City of Albuquerque Stormwater Construction Site Inspection Report

Project Name and Location	Behavioral Health Hospital 1525 Renaissance Blvd NE		
Site Contact Name & Agency	Daniel Pruitt Jaymes Corp	ESC File No. NPDES ID No.	F16 E051A NMK 1001 R6
Date of Inspection	12-14-18	Start/End Time	9:45/10:05
COA Inspector Name	Curtis Cherne, Stormwater Quality		
Describe Present Phase of Construction	Over-ex		
Type of Inspection:	<input type="checkbox"/> Regular <input type="checkbox"/> During storm event <input type="checkbox"/> Post-storm event (> 0.25 inch) <input type="checkbox"/> 311 / Complaint Response <input checked="" type="checkbox"/> Follow-Up

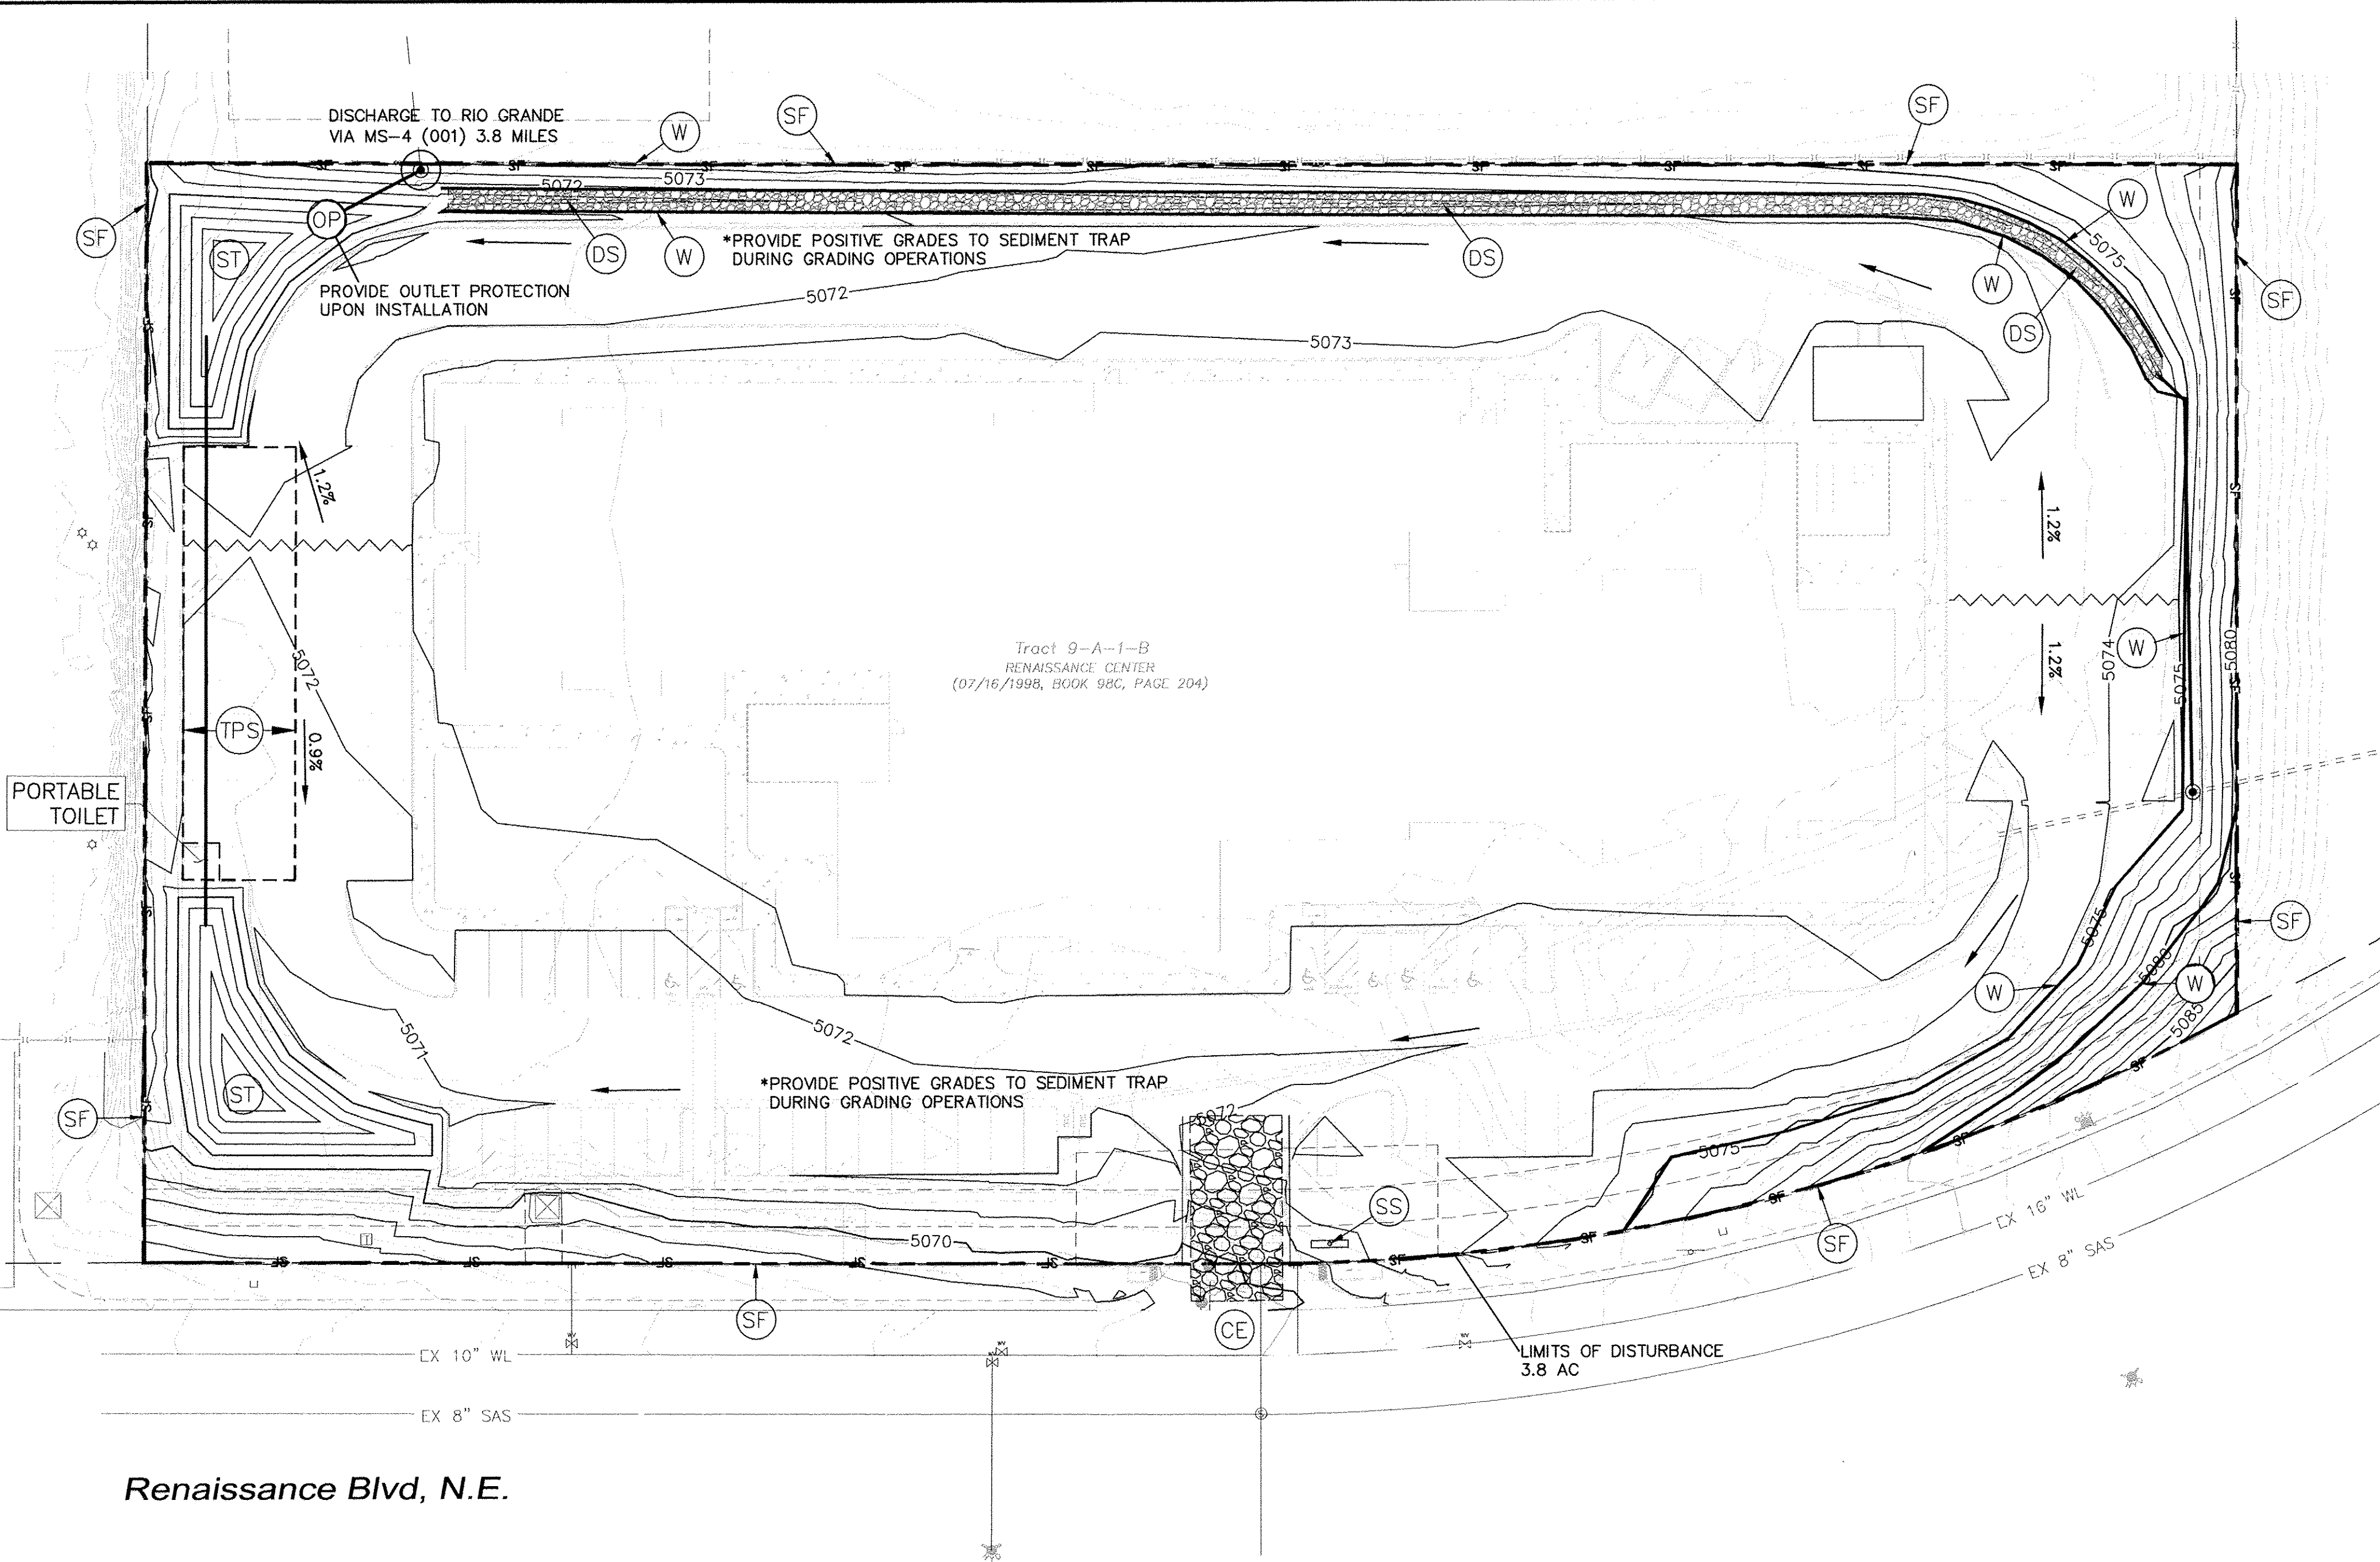
CGP ¹ Section	BMP / Activity	Maintenance or Corrective Action Required	Location and Notes
1.5	Post a Notice		
2.2.1	Provide and maintain Natural buffer when Waters of the US < 50 ft		
2.2.3	Sediment control along any perimeter	✓	silt fence not buried west edge ~ soft
2.2.3	Sediment control along any perimeter	✓	gap in silt fence south side - fine hydrant
2.2.3	Sediment control along any perimeter		
2.2.3	Sediment control along any perimeter		
2.2.3	Sediment control along any perimeter		
2.2.3	Sediment control along any perimeter		
2.2.3	Sediment control along any perimeter		
2.2.4	Minimize sediment track-out	✓	no aggregate between slabs and curbs

2.3.3	Fuel, oil, hydraulic fluid, petroleum products and chemical storage		
2.3.3	Construction and Domestic Wastes	✓	trash NE corner
2.3.3	Construction and Domestic Wastes
